RE: Love's Travel Stop SEPA (SE-19-00014)

The following are my comments on the above referenced SEPA Environmental Checklist. This document contains erroneous information, vague and incomplete information. The Traffic Impact Analysis contains many errors and does not put forth the image a professionally prepared document. To put it honestly the person who prepared it does not demonstrate the ability to read a map. Close scrutiny of this report, by CDS and Public Works, should be in required.

PRELIMINARY STORMWATER PLAN
LOVE'S TRAVEL STOPS
EASTON, WA

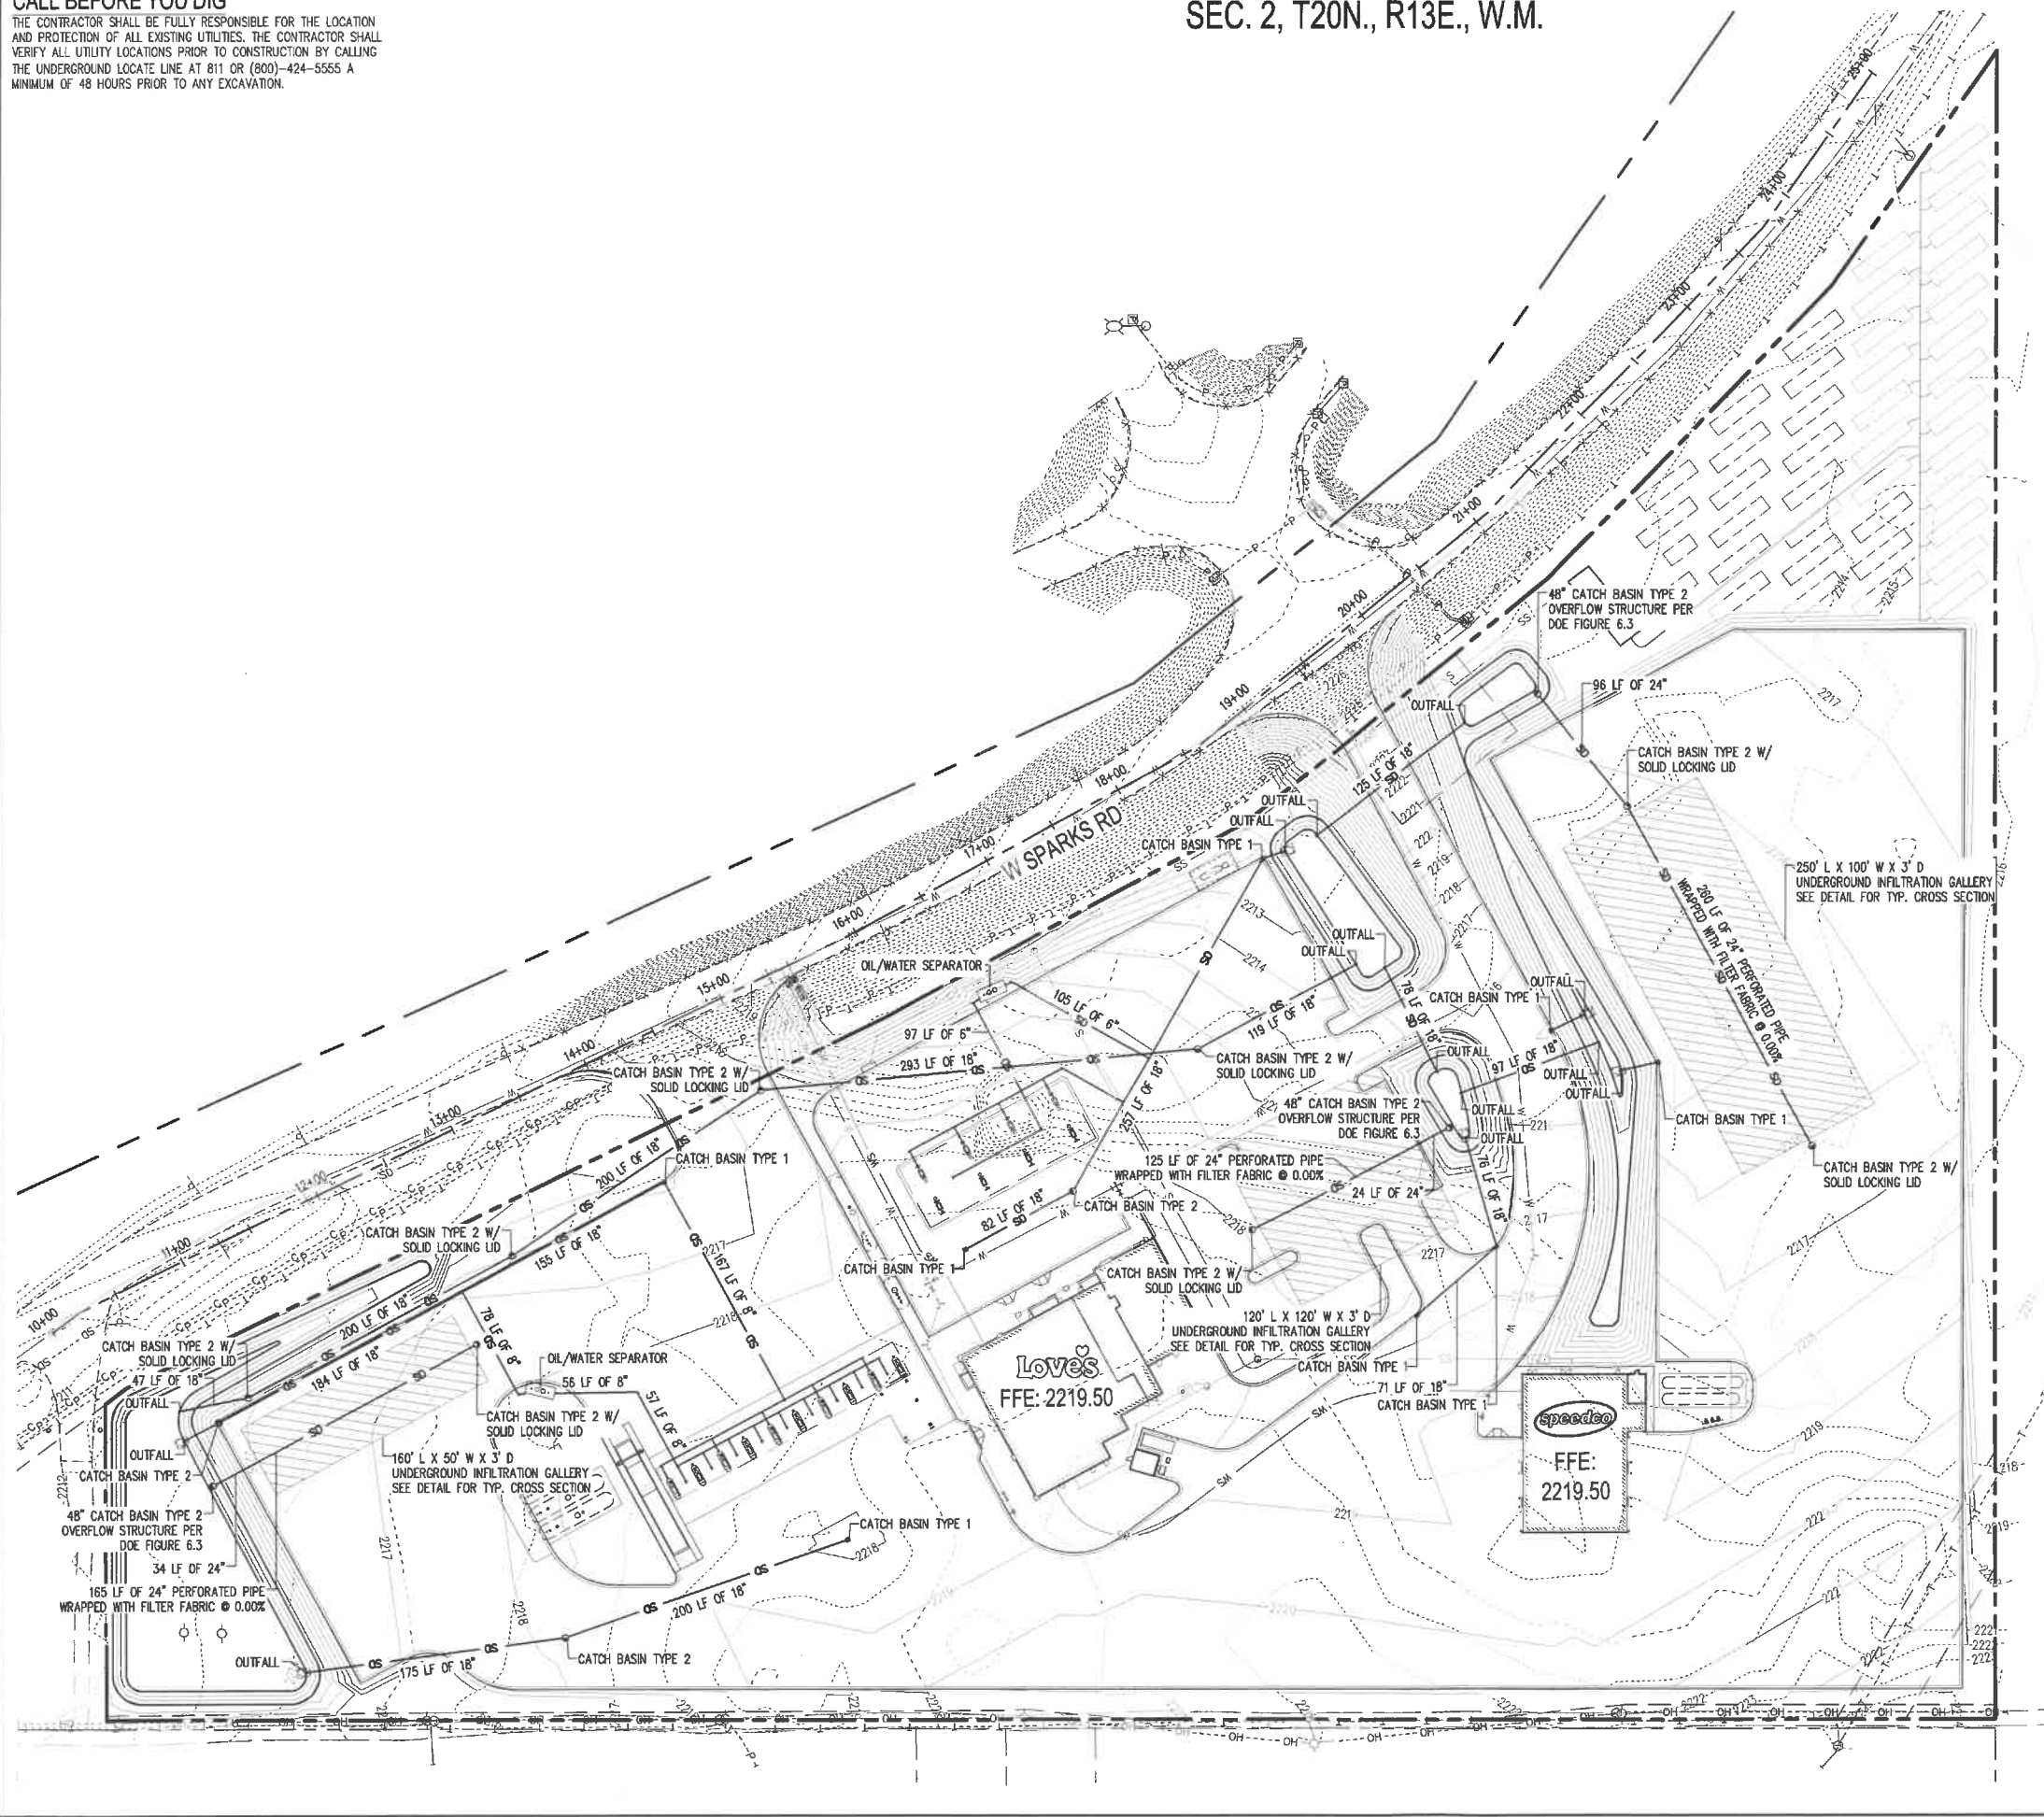
1) The answer to this question requires additional information also. There is no statement describing the source of runoff or the method of collection and stated treatment. I also believe there should be an estimated quantity included. The fact that 74% of the proposed development will be impervious should require some detailed estimates of septic and stormwater quantities to be infiltrated in to the remaining 26%.

2), 3) Stormwater runoff in the Easton area can be a problem during times of snow melt and can cause flooding and standing water if the system is not designed adequately. Inadequate control of stormwater on such a large impervious area could cause local flooding and possible runoff on to abutting properties. Untreated runoff could likely contain large amounts of commercial de-icer and snow melt chemicals. Any petroleum products and other hazardous materials which may have been deposited over the winter months when detecting, containing and cleanup of would also by pass any treatment process and be deposited in unintended areas.
